Re: CU-20-00006

WLC PROPERTY HOLDINGS LLC
SITE PLAN

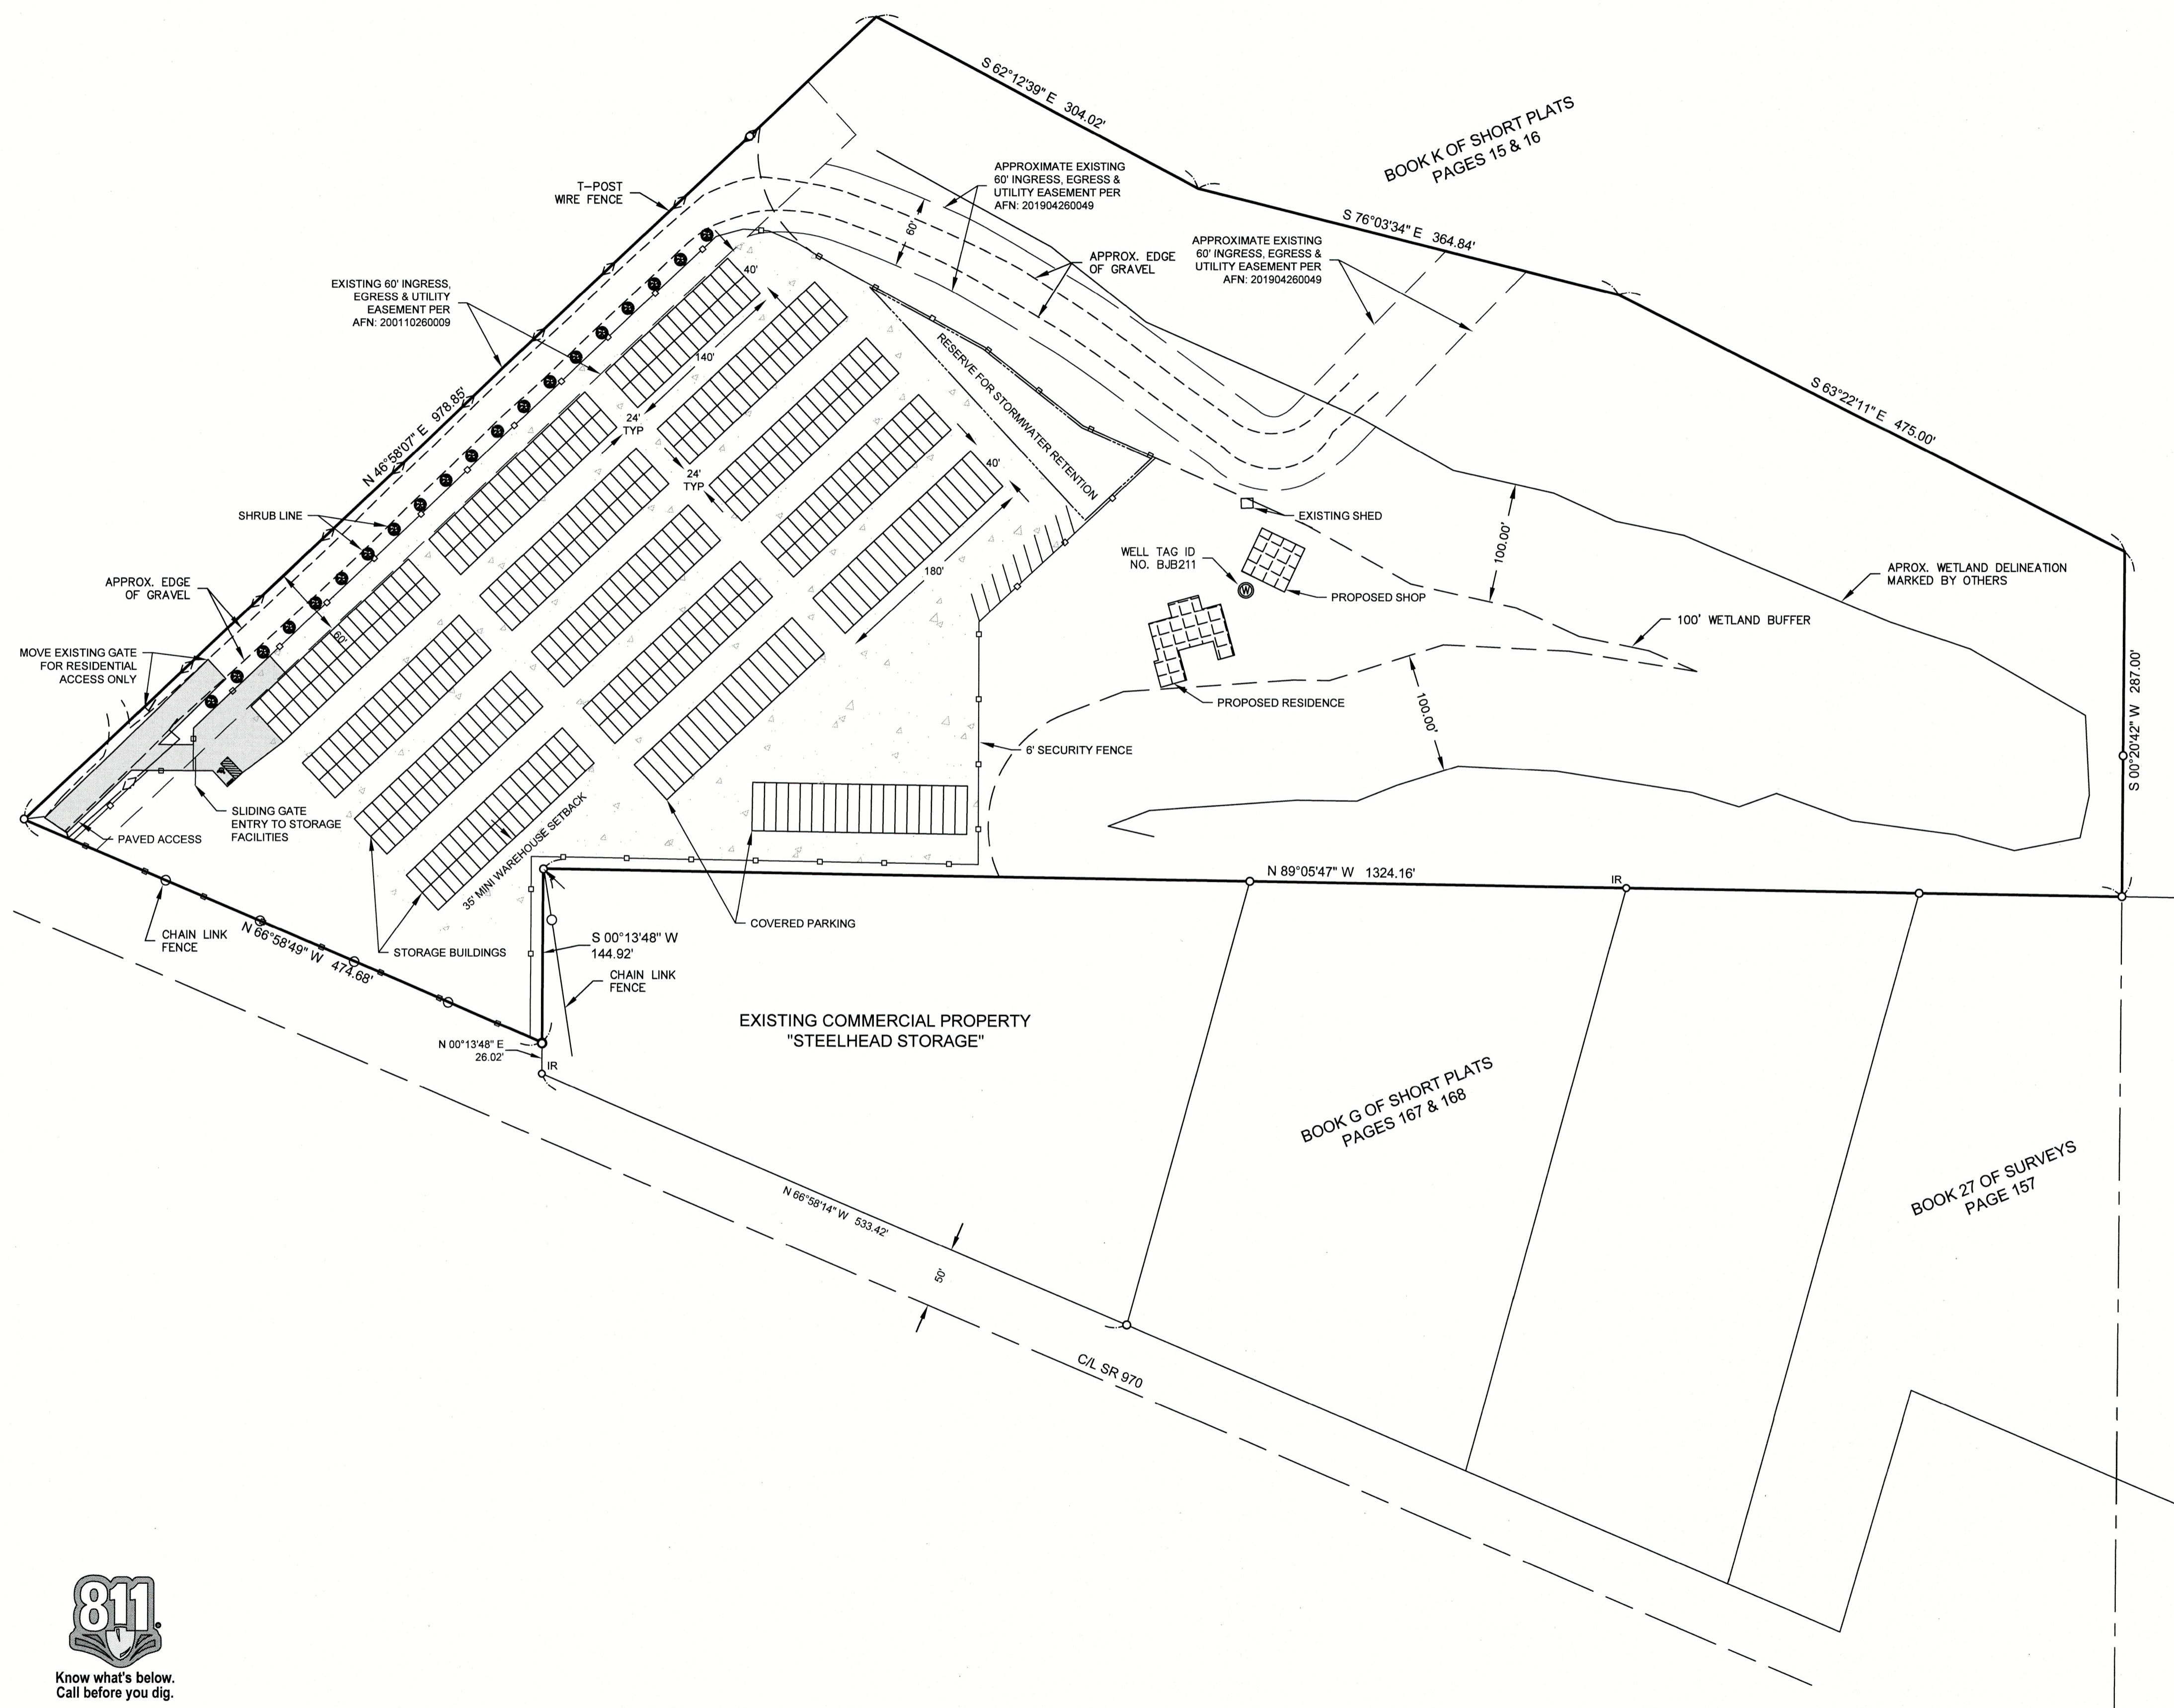
Border with Todd Crooks. Trees beyond gravel road to be removed per drawing, eliminating any buffer
